HIGHWAYS TECHNICAL NOTE

Plot 2, Carlton Industrial Estate, Industry Road, Carlton

24663-DR-C-0100

The Highways Technical Note has been produced by Dart Engineers to outline responses to the Highway Authority comments used relating to Planning Application Reference 2024/0668 for the site below:

Tracking Layout - Access

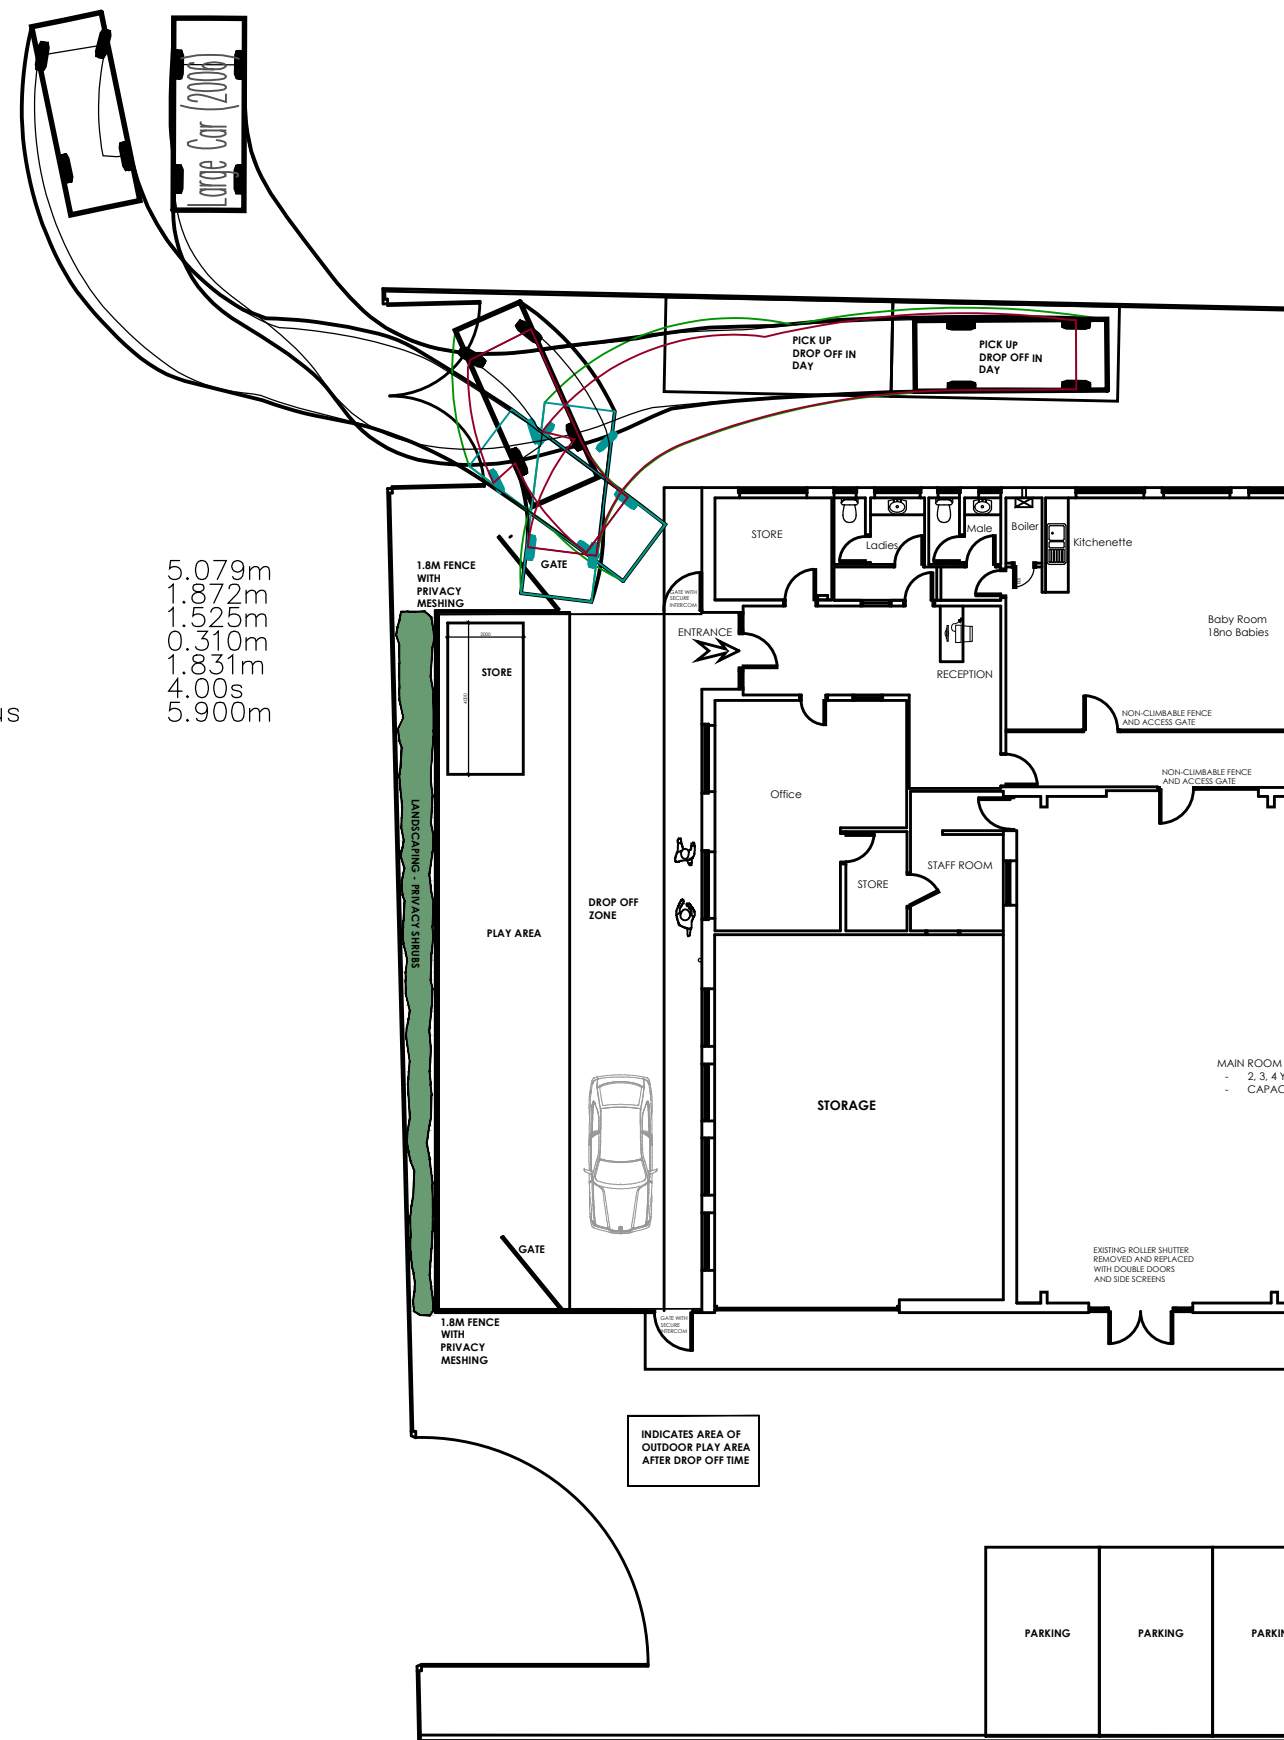
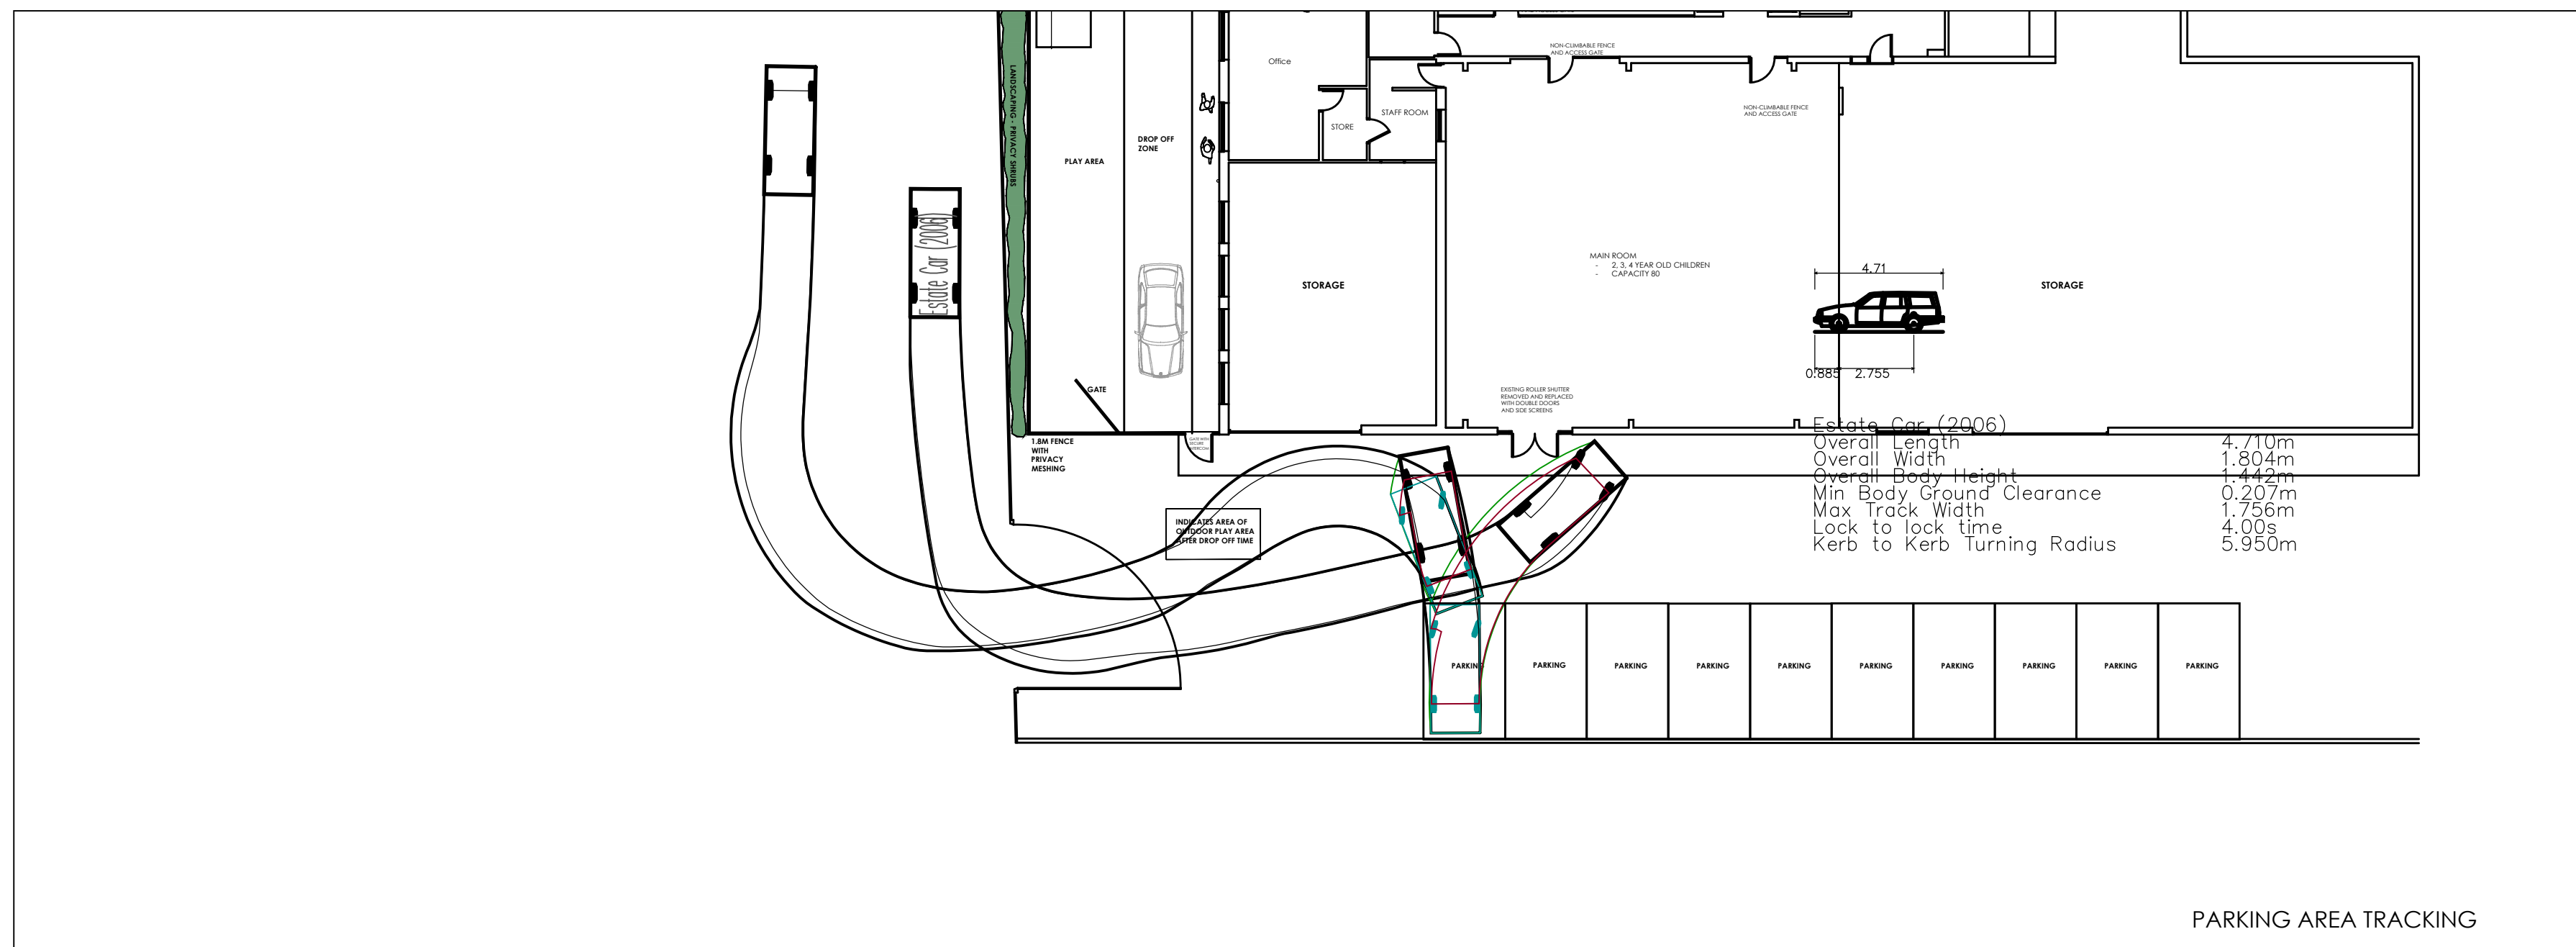
The proposal to use the drop-off and collection zone as a secured play area for the nursery raises practical concerns. If gates are required to secure this area, the applicant should clarify the arrangements for unplanned vehicle access, such as when a child needs to be collected during the day due to illness or other unforeseen circumstances. The feasibility of accommodating such scenarios while maintaining safety and functionality has not been adequately addressed.

The proposed parking layout for the site also raises significant concerns. The proposed longitudinal parking spaces lack sufficient room for vehicles to manoeuvre and exit without reversing the entire length of the site. This parking area is also identified as a shared access route to an adjacent unit, which the site plan notes is used primarily at weekends. However, such access cannot be guaranteed, and the proposed parking layout obstructs this route. Highways Development Control cannot support a proposal that compromises access for neighbouring units.

Notwithstanding this, echelon parking should be designed to ensure that vehicles can reverse into the space however, the design of the echelon parking spaces does not allow for vehicles to reverse into them and given that there is inadequate manoeuvring space, this will likely result in vehicles reversing the entire length of the site to exit. This presents serious safety concerns, particularly given the presence of young children in the vicinity.

As noted the gates will only be opened in pick up and drop off times at the start and end of the day. They will be locked in all other times. The parking arrangement have been modified on DART Engineers drawing 246633-DR-C-0100 so two pick up drop off spaces are provided to the north of the site for use during day time hours and these can be accessed and existed in isolation as shown.

As noted above – the northern section has been amended to have 2 no. pick up and drop of spaces for use in the day only. The southern area has been revised to provide 5x3m standard head on spaces which can be accessed and existed as shown.

The existing access to the unit on the north is only used for weekend deliveries and access is not required during the weekday operation of the Nursery.
